Doc no. DOC19/593791
File no. SF19/76662

**RE: Response to Response to Submissions (RTS) of Sydney Opera House (SOH)
Building Renewal Program – Concert Hall Upgrade and new Creative Learning Centre
(SSD 8663)**

ATTACHMENT A: SYDNEY OPERA HOUSE BUILDING RENEWAL PROGRAM
CONCERT HALL & CREATIVE LEARNING CENTRE HERITAGE RESPONSE TO
SUBMISSIONS RESPONSE

Project	BUILDING RENEWAL PROJECT - CONCERT HALL		
Title	DETAIL PLANS 2 - LIFT 30

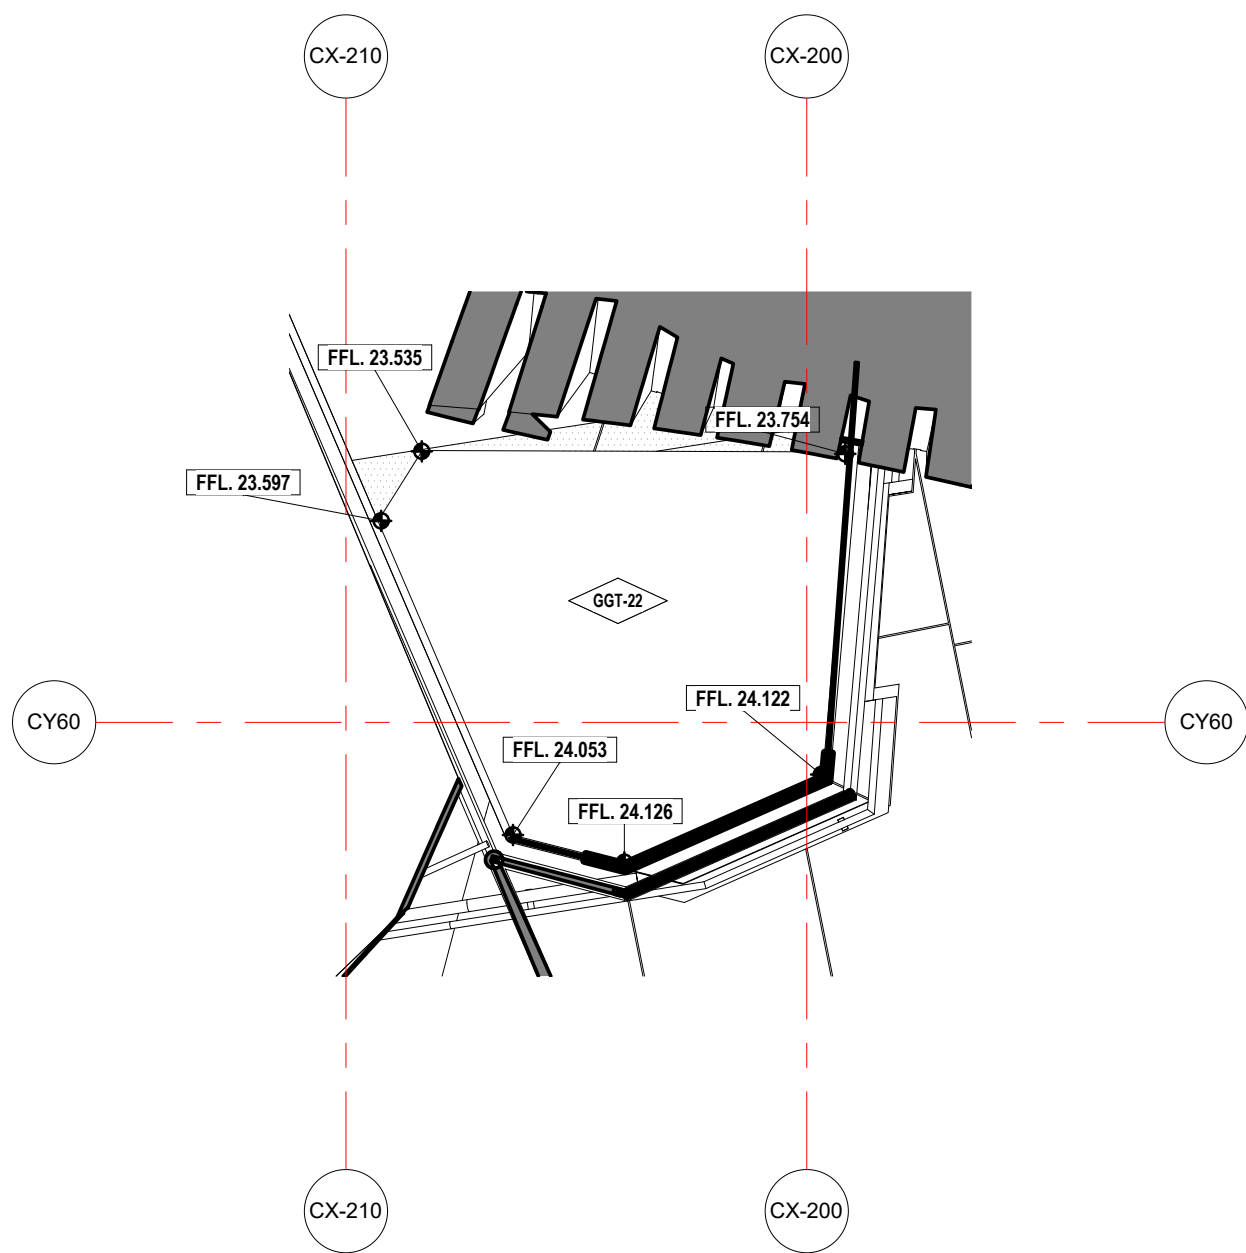
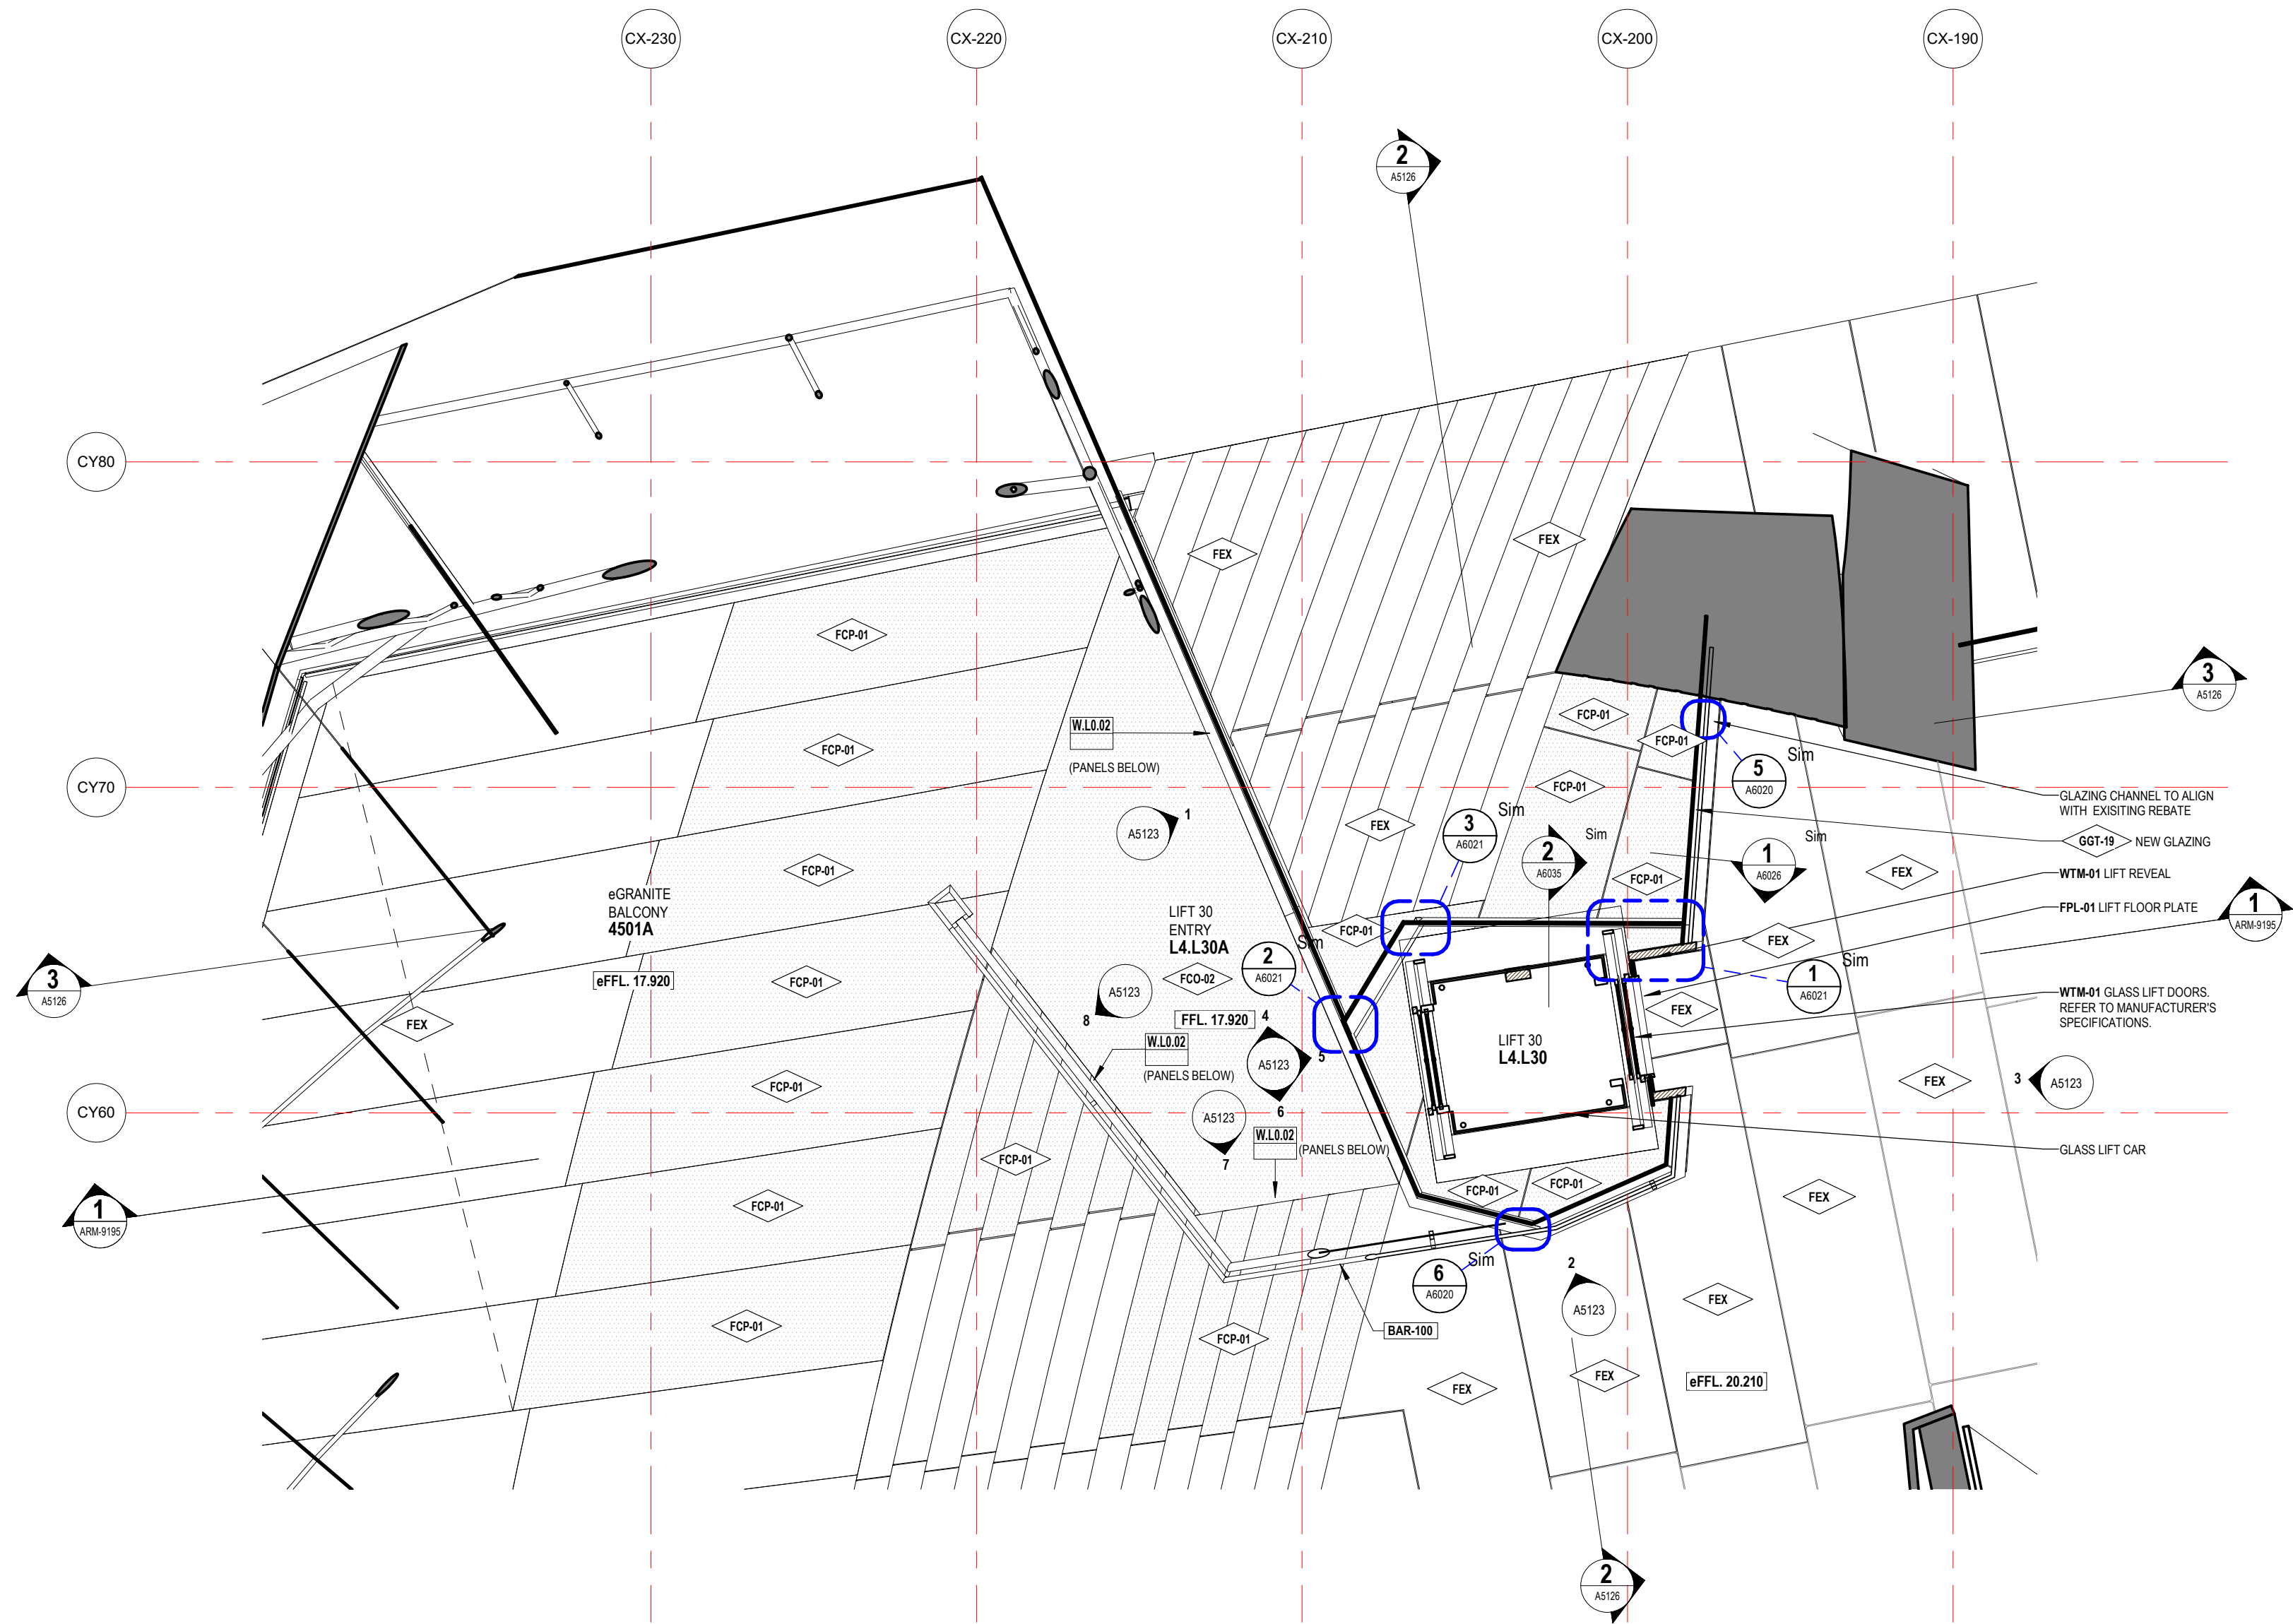
- 2.23 It is still considered that the proposed detail to extend two beams to the new lift adversely impacts the aesthetics of the distinctive bend line of the cranked beams. The design of this detail requires further refinement to better integrate the beams within the existing significant design aesthetic and minimise visual impacts.

- 2.24 The proposed detail of the extension of two cranked beams connecting to the new lift should be reviewed and revised to minimise visual impacts and to ensure the new works do not disrupt the aesthetic qualities of the distinctive line of crank points in the beams.
